Subject: RE: 2 x DoC applications for Part of former St Luke's Hospital site, Blackmoorfoot Road, Crosland Moor, Huddersfield, HD4 5RA [LICH-DMS.FID204230]

[2025/92676 - Discharge of details reserved by conditions 12 \(retaining walls\), 17 \(carbon emissions\), 18 \(crime mitigation strategy\), 20 \(noise assessment\), 21 \(materials\), 23 \(boundary treatments\) and 32 \(delivery noise management plan\)](#)

[2025/92535 - Discharge of details reserved by conditions 9 \(temporary drainage\), 14 \(oil/petrol interceptor\), 15 \(flood routing\), 16, \(drainage strategy\), 19 \(landscaping\)](#)

Client	LiDL						
Project	Proposed LiDL Foodstore Crosland Moor						
Drawing title	Drainage Strategy						
Drawn	JS	Chkd	RT	Date	August 2022	Scale	As Shown
Sheet Size	A1	Drawing No.	21561-DR-C-0100	Revision			P7

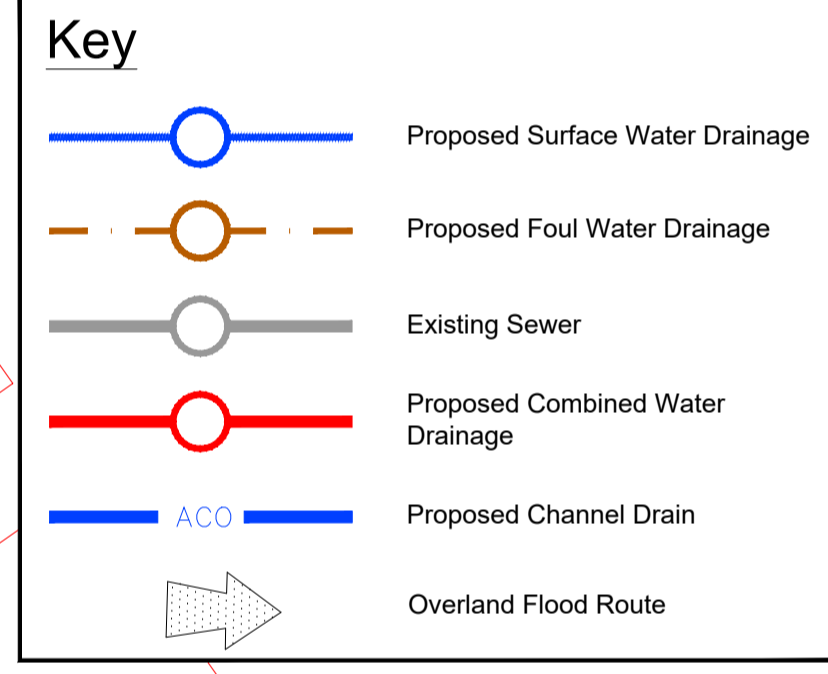
A layout plan and supporting calculations have been submitted. To help support these, a coloured plan showing hardstanding areas contributing to each leg of surface water sewer is required so it can be cross referenced with the hydraulic simulation. A plan and cross section of the tank should be submitted to go alongside the access and maintenance and management plan.

We do have concerns over a connection of a crate storage tank to a combined sewer in case this system surcharges and clogs up the crate storage reducing its capacity and therefore long-term compliance with drainage technical standards. This should be reviewed and the design justified, or risk adequately mitigated.
